**From:** Vanessa Aziz <vaziz@cityofsydney.nsw.gov.au>  
**Sent:** Tuesday, 29 May 2018 1:07 PM  
**To:** Ellen Mannix  
**Subject:** City of Sydney Response - Alterations and Additions (SSD 7056 MOD 2) 7-27 Circular Quay West, The Rocks  
**Attachments:** SSD 7056 MOD 2 - Notice of Exhibition - Letter to Council.pdf; SSD 7056 MOD 2 - Campbells Stores The Rocks Mod Exh Advert.pdf

- Amendments to mechanical equipment and roof space of Bay 11;
- New powder-coated louver wall added to the loading dock;
- Reconfiguration of the Bay 6 ground level toilet layout;
- Two new air vents behind eastern eave of Bay 6; and
- New internal opening at Level 1 between Bays 8 and 9.

Drawing Title  
**ROOF PLAN**  
 JPW Project Number  
**12006**  
 Drawing Status  
**EA**  
 Drawing Number  
**EA-A-1006**  
 Revision  
**D2**

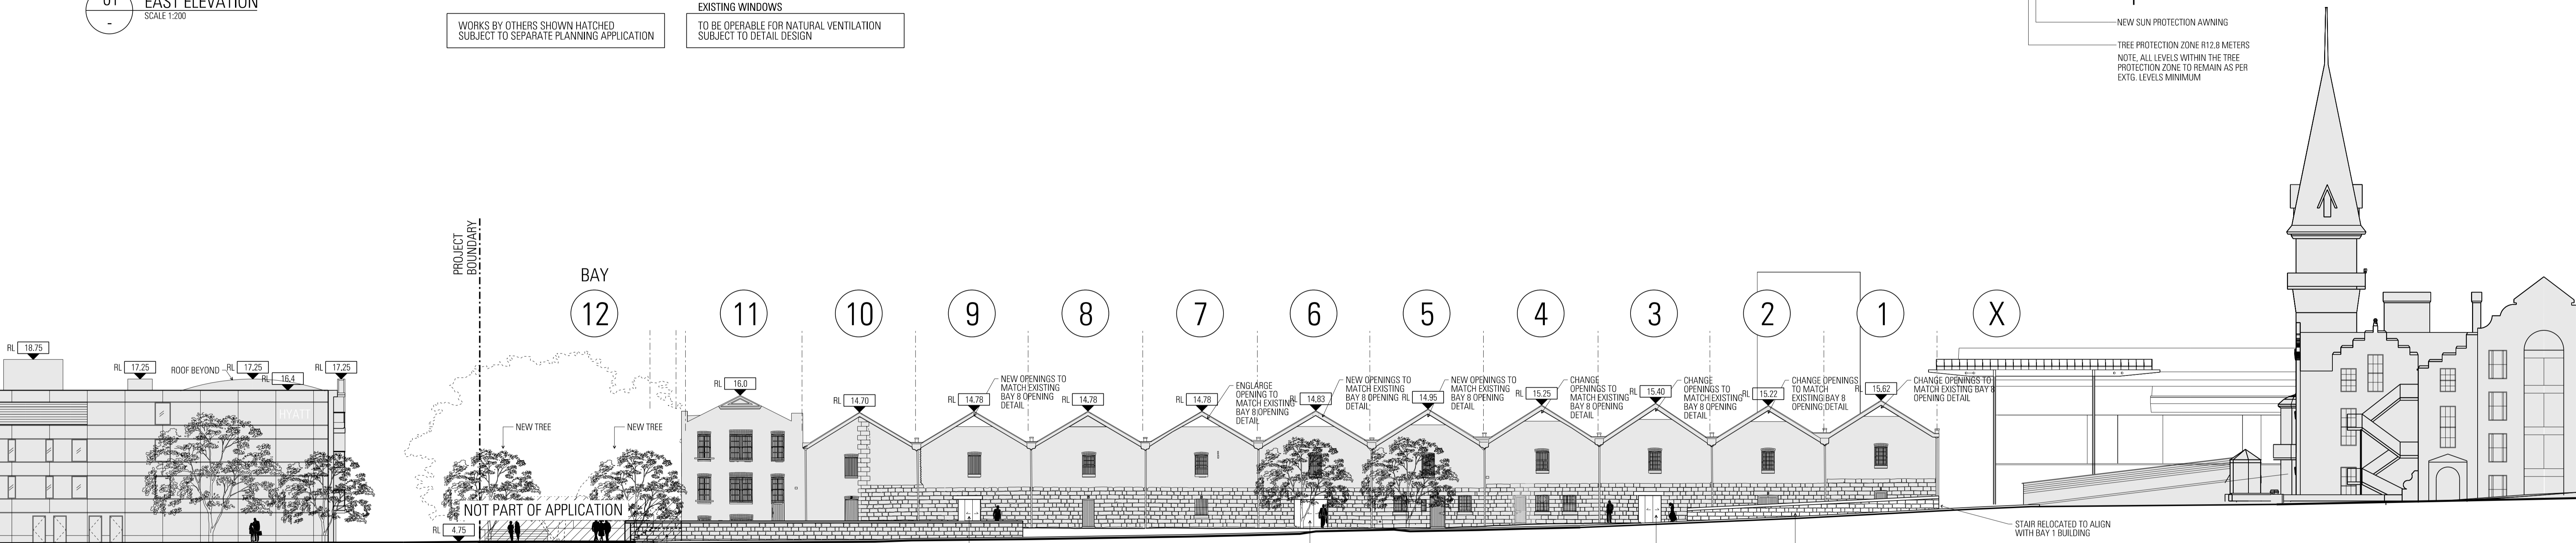
- The change from an electrical generated mechanical system to a gas fire system, will result in larger roof openings in Bay 11, but this will be mitigated by the installation of a fine mesh over them, the colour of which will match adjoining roof. As demonstrated in the visual impact assessment, these changes will have a minor but acceptable visual impact, and with the use of a mesh covering, the roof openings will be less evident visually than the openings previously approved. The roof cladding is not original fabric.
- The other changes are considered to be minor and will have little heritage impact.
